CITY OF CHARLOTTE
DEPARTMENT OF TRANSPORTATION

May 7, 2018

It is our understanding that the United States Corps of Engineers (USACE) is recommending the study of the red and orange alignments as a possible Concurrence Point 2 alternative for NCDOT project U-5768. After reviewing these study alignments, the City of Charlotte has determined that they are not consistent with multiple City policies, guidelines, and our goal of protecting and preserving existing neighborhoods. Based on our review, the City does not support further consideration of the red and orange study alignments, and offer the following information for consideration by the USACE.

# 1989 ECR Report

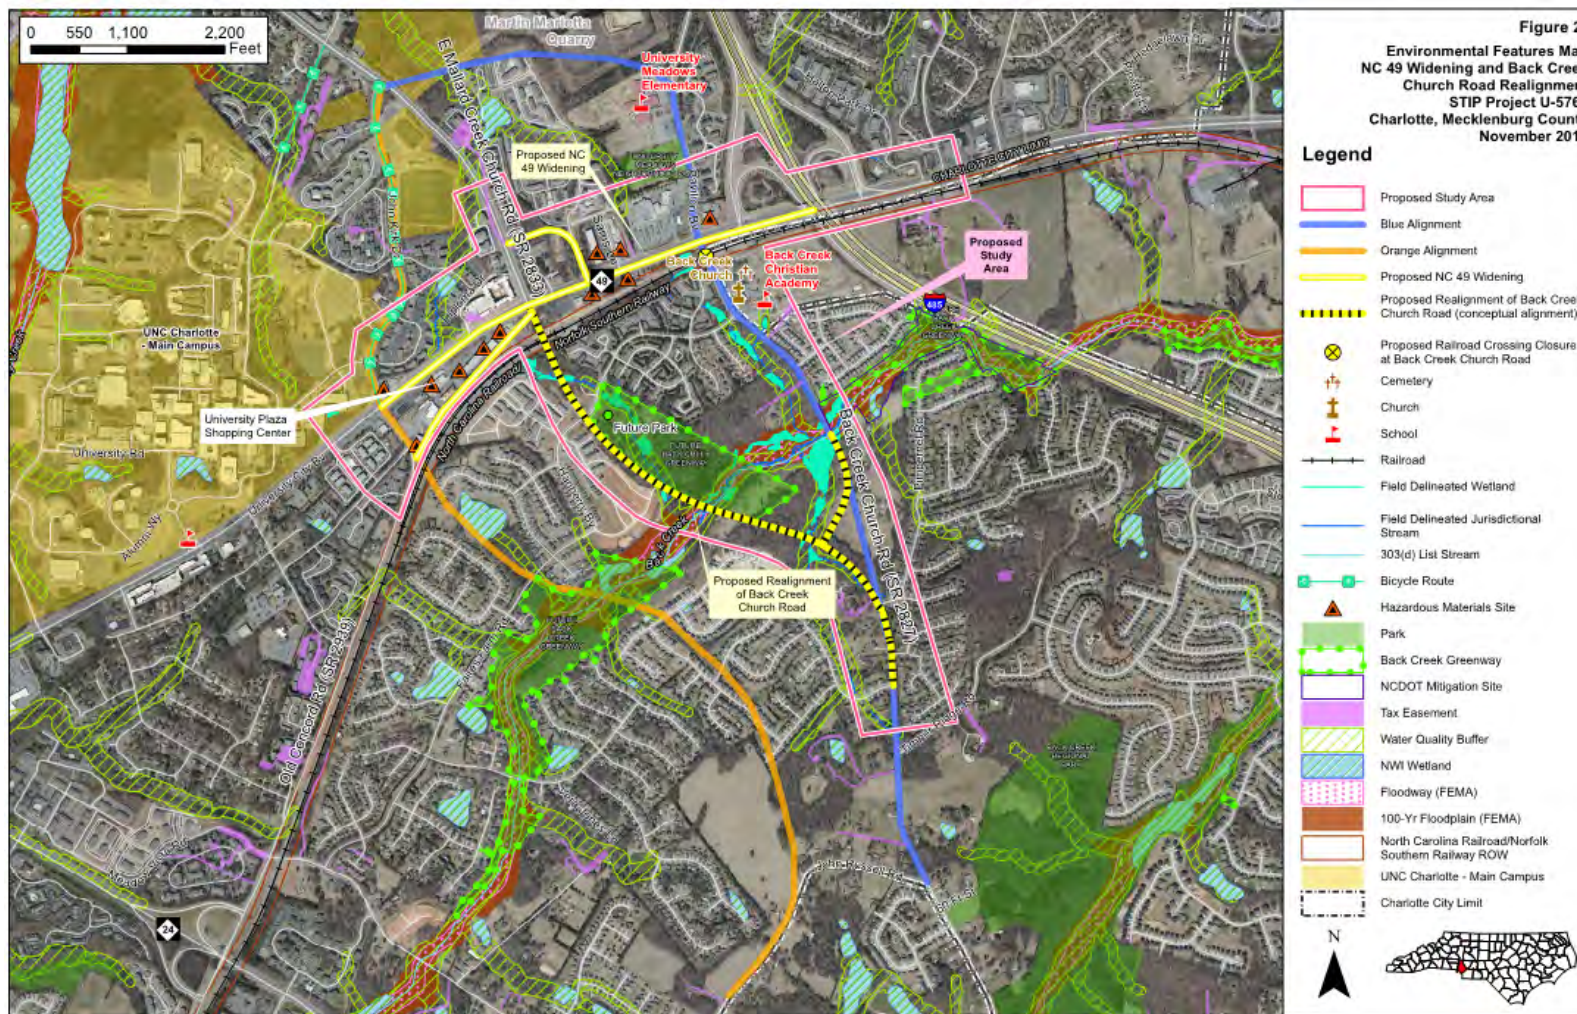
The 2006 Rocky River Road Area Plan identifies an alignment that is consistent with the ECR preferred alignment. While expanded connectivity is important, and identified as a goal or guiding principle in both in the Rocky River Road Area Plan and Charlotte's overall growth framework, Centers, Corridors, and Wedges, protection and enhancement of established neighborhoods is also a priority. Centers, Corridors, and Wedges states that, "Strong and attractive neighborhoods are key to Charlotte's success and long term viability. The City places a high value on its established neighborhoods, and our quality of life is determined by their livability and character." We believe the red and orange alignments would significantly impact the quality of life, livability and character of the existing neighborhoods.

While we appreciate the opportunity to participate in the Concurrence Point 1 & 2 processes, the City of Charlotte does not support further study of the proposed red and orange study alignments, given their incompatibility with the City's existing policies and guidelines and established neighborhood patterns. Furthermore, the City does not support the significant neighborhood impacts to The Villages at Back Creek and Wyndham Place communities. We respectfully request that the red and orange study alignments be eliminated from further consideration for Concurrence Point 2.
